Application no: H16-0255-11

Description: Proposed two-storey extension

Amendment: Amendment to rear elevation (dwg. no. WEN/1421/11/00)

ACKNOWLEDGEMENT OF AMENDMENT

DRAWING N°: WEN/1421/11/00	DATE: MARCH 2011
-------------------------------	---------------------

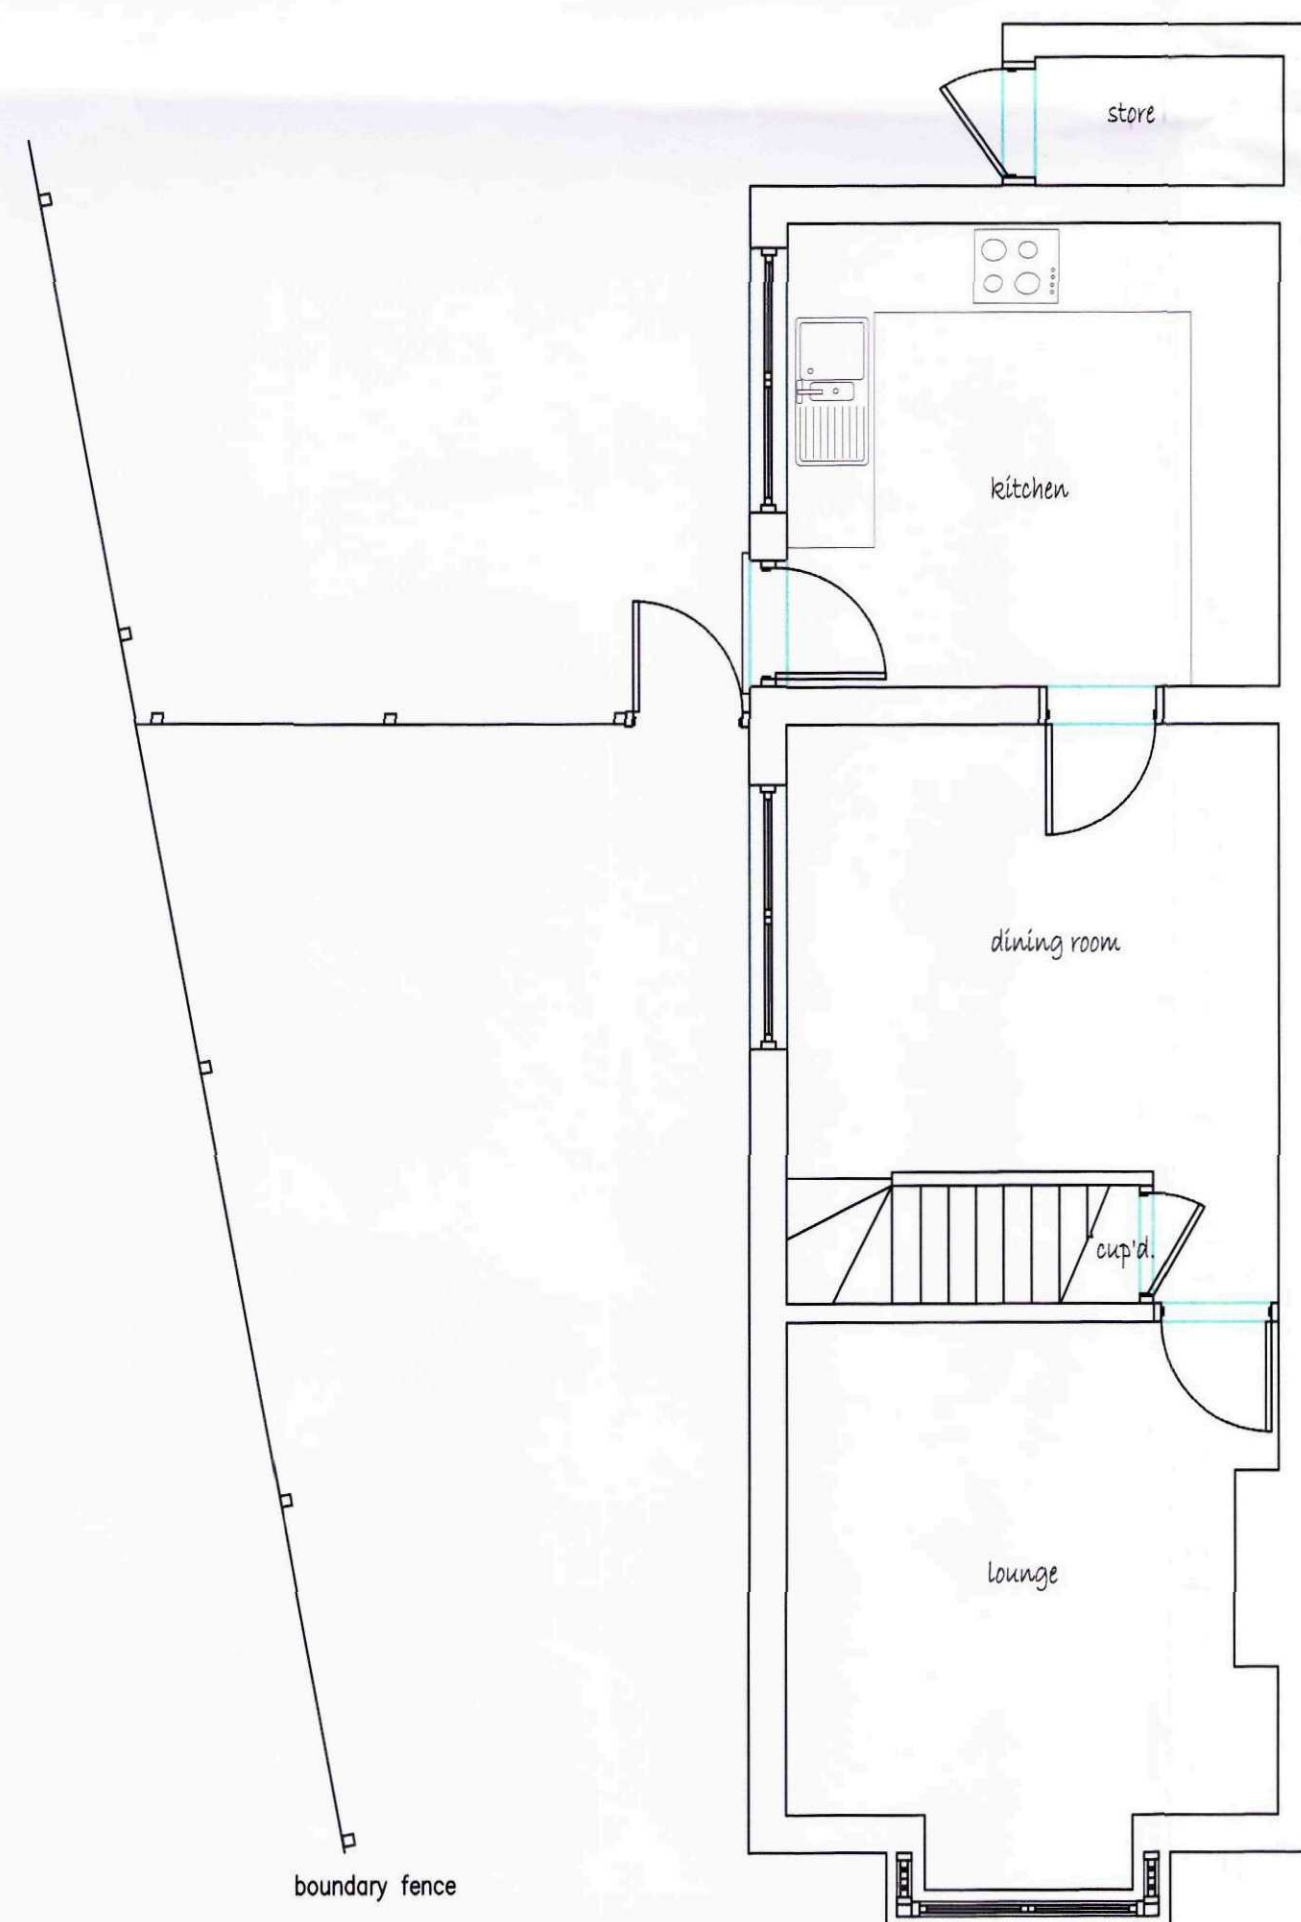
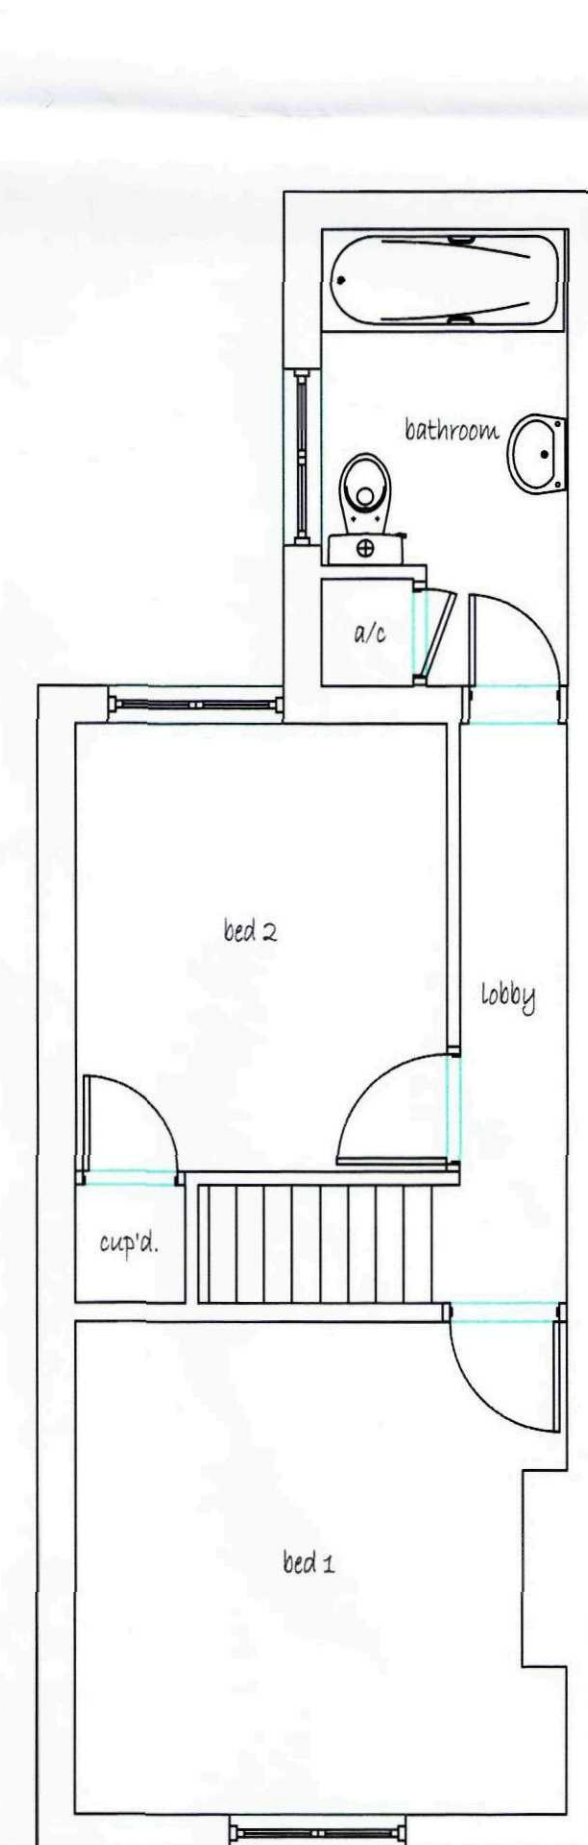
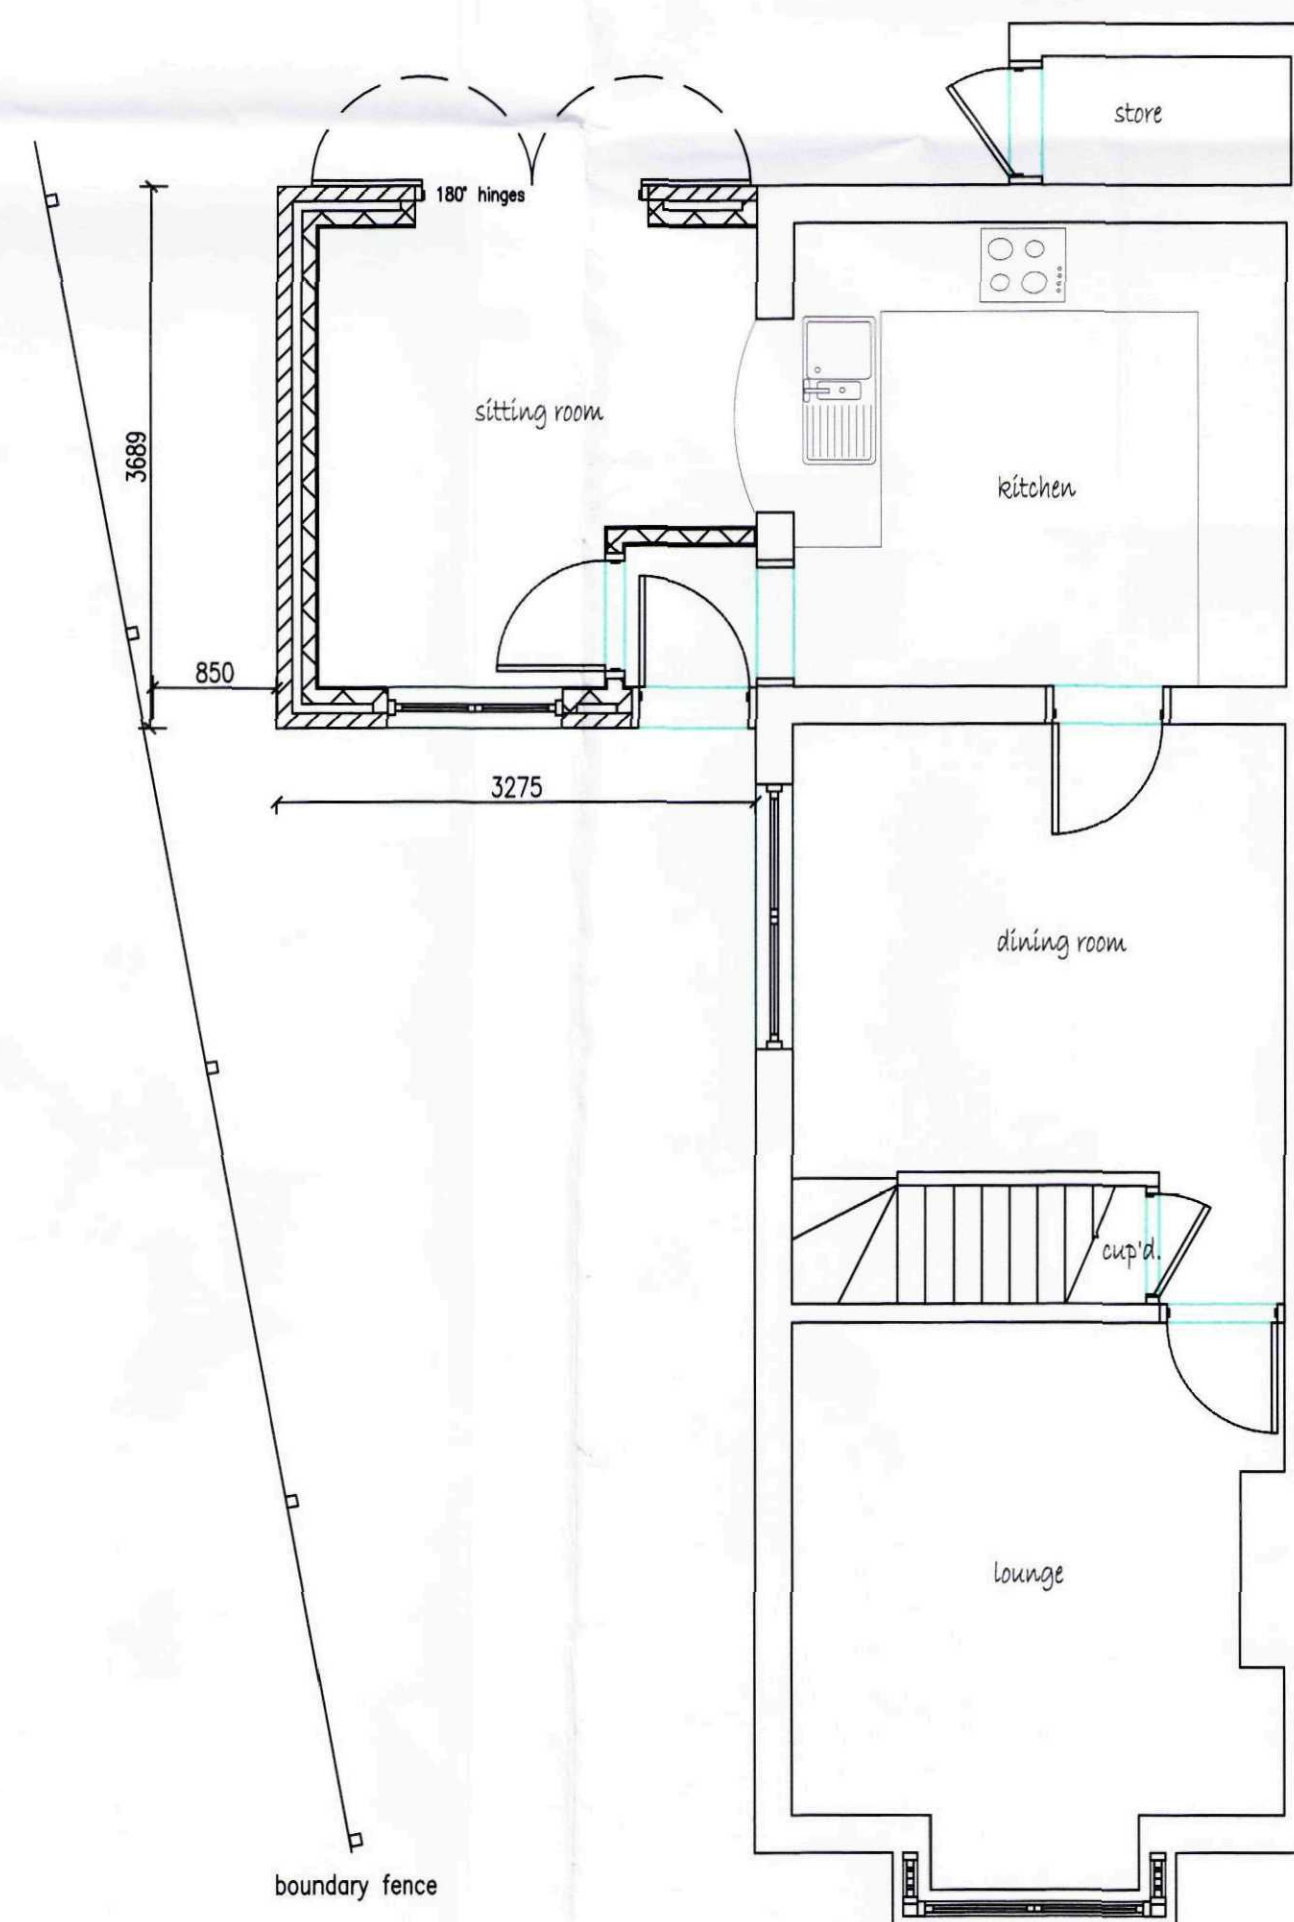
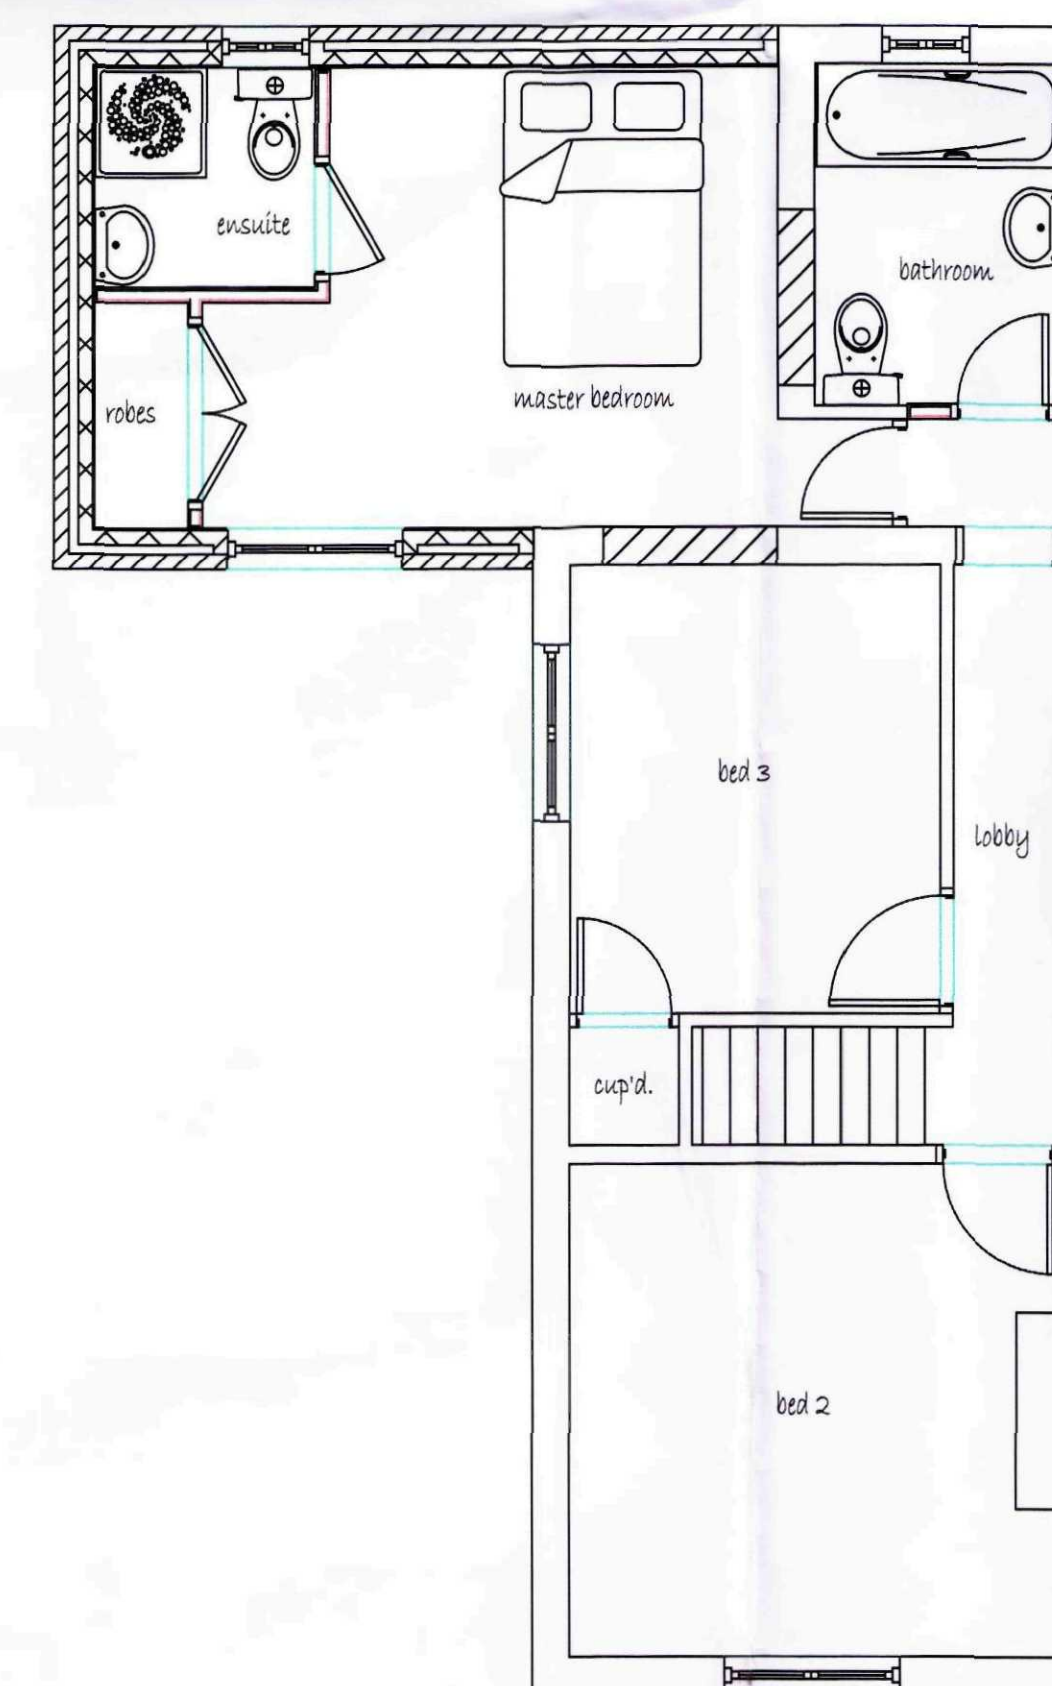
Sorry to be a nuisance but I attach herewith an amended drawing which shows the proposed rear elevation altered.

The amendment consists of a velux window being added to the rear. I hope that's ok, please could the other plan be disregarded.
